Project	Cliffe Lane, Gomersal -Application Number 2023/92966	Document No	152130-006-001
Subject	Technical Note - Highway Response to comments received

Sanderson Associates Consulting Engineers (SACE) has been appointed to provide Highway Consultancy Services in relation to proposals for the residential development of 87 dwellings on land to the west of Cliffe Mount, Ferrand Lane, Gomersal.

Copy Of Phoenix 2 Duo Recycler (P2-15W with Elite 6x4 chassis)
 Overall Length 11.850m
 Overall Width 3.750m
 Overall Body Height 2.530m
 Min Body Ground Clearance 0.309m
 Track Width 2.530m
 Lock to lock time 4.00s
 Wall to Wall Turning Radius 11.035m

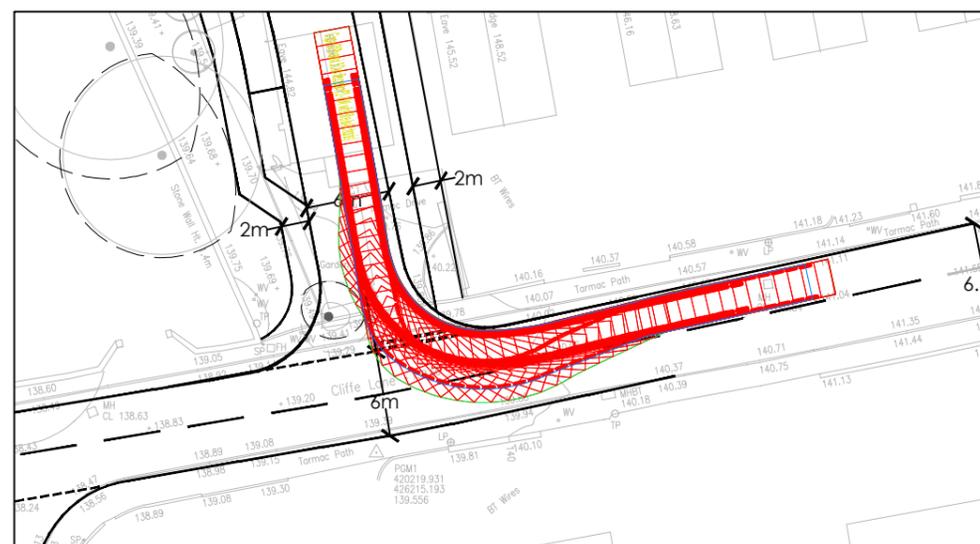
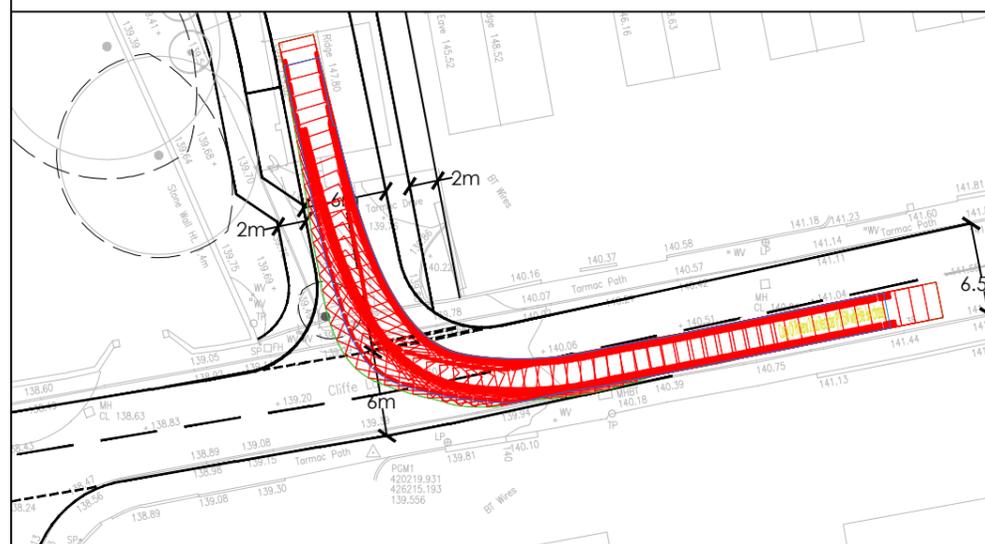
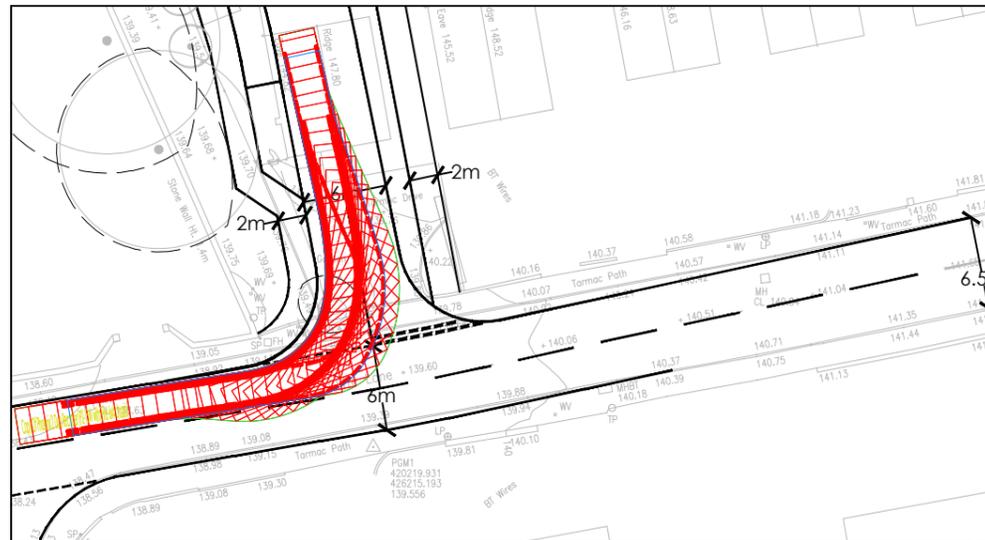
The Section 38 Adoptions Team Engineers comments are “the RSA1 Designers Response has not accepted the RSA Recommendation which is not acceptable. The previous RSA was rejected because it was over five

years old and whilst the Developer has claims this was previously accepted our design standards have moved on since and hence the new RSA Recommendations will need to be resolved”.

The RSA raised two points, the RSA response accepted one point and did not accept the other point. The RSA response to the point not accepted stated.

Kirklees Highway Design Guide was adopted in November 2019. The roads within the site are classed as Local Residential Street (Type B). **Table 5: Recommended guidelines for junction radii and visibility layouts**, identifies that the access should be provided with 6m radii. It can be confirmed that the site access junction onto Cliffe Lane is provided with 6m radii and is provided in accordance with recommended guidelines. Whilst it is noted that the Highway Design Guide was adopted in November 2019, 8 months after the original RSA was completed, it is understood that the geometry requirements were unchanged from the council’s previous guidance. Consequently the council comment in this respect is considered to be irrelevant.

In this particular case the Design Team does not consider it necessary or appropriate for alterations to be made to the proposed access arrangements to enable a refuse vehicle to access and egress the site without utilising the full width of the carriageway.

This view is supported by guidance contained within Manual for Streets paragraph 6.8.1 on the basis that a refuse vehicle would visit the site on an infrequent basis, typically once per week. Similarly other larger servicing or delivery vehicles would also be expected to access the site on an infrequent basis. Such a situation exists at neighbouring junctions and has done for many years with no indication of any issues arising.
